August 14, 2017

RE: **Shawn McWethy Park – Phase 2A**  
**Grading Plan**  
**Plan Date 8/9/17**  
**Hydrology File: J09D023A**

Based upon the information provided in the submittal received on 8/8/17 the above-referenced Grading Plan cannot be approved for Grading and Paving Permit until the following are addressed:

SHAWN MCWETHY PARK PHASE 2A
GRADING PLAN

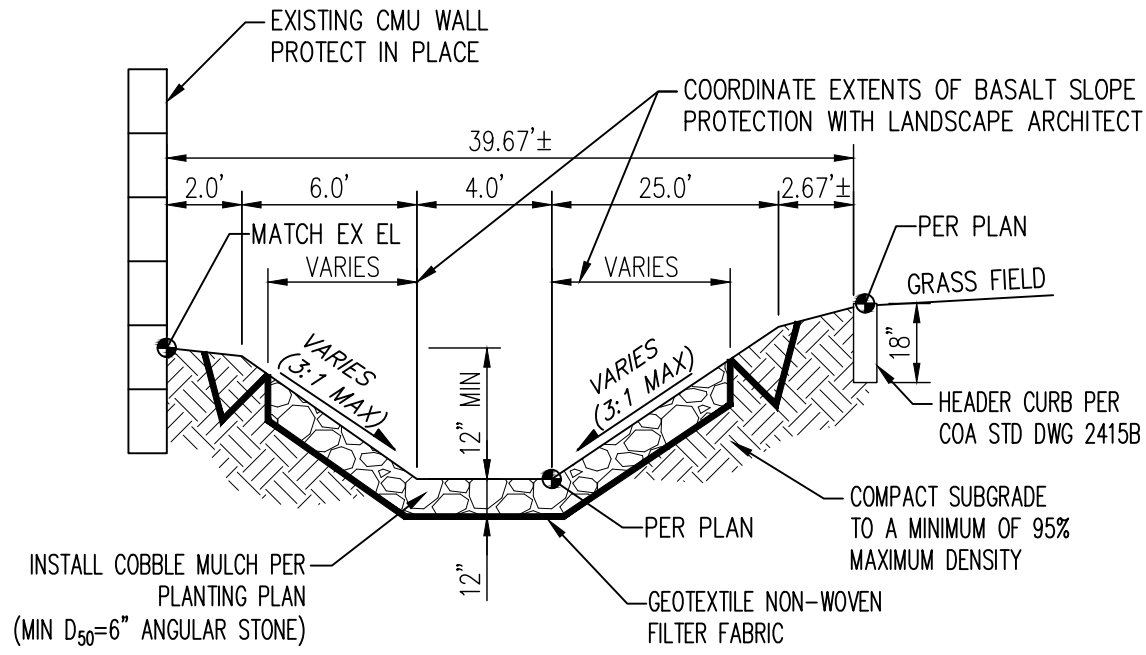
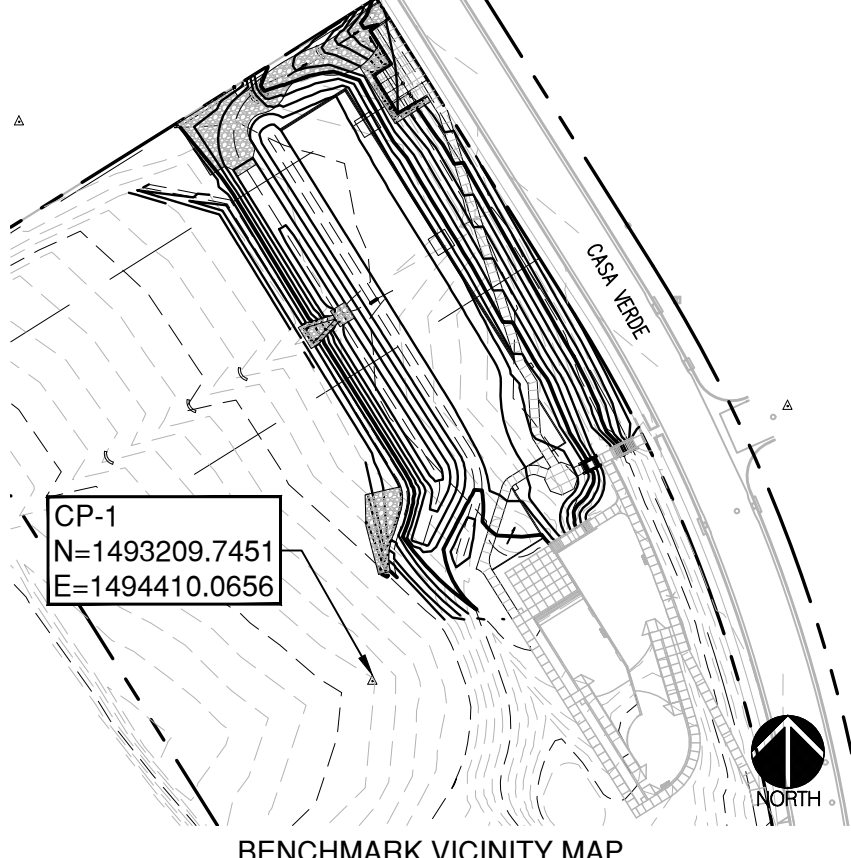
1. The Grading Plan needs to be sealed by a NM PE.
2. Include benchmark and elevation data.
3. The temporary desilting pond on the west side of this phase needs to include an armored spillway or be sized for its 100yr, 10day volume.
4. Include the 100-yr MWSE on section B-B.
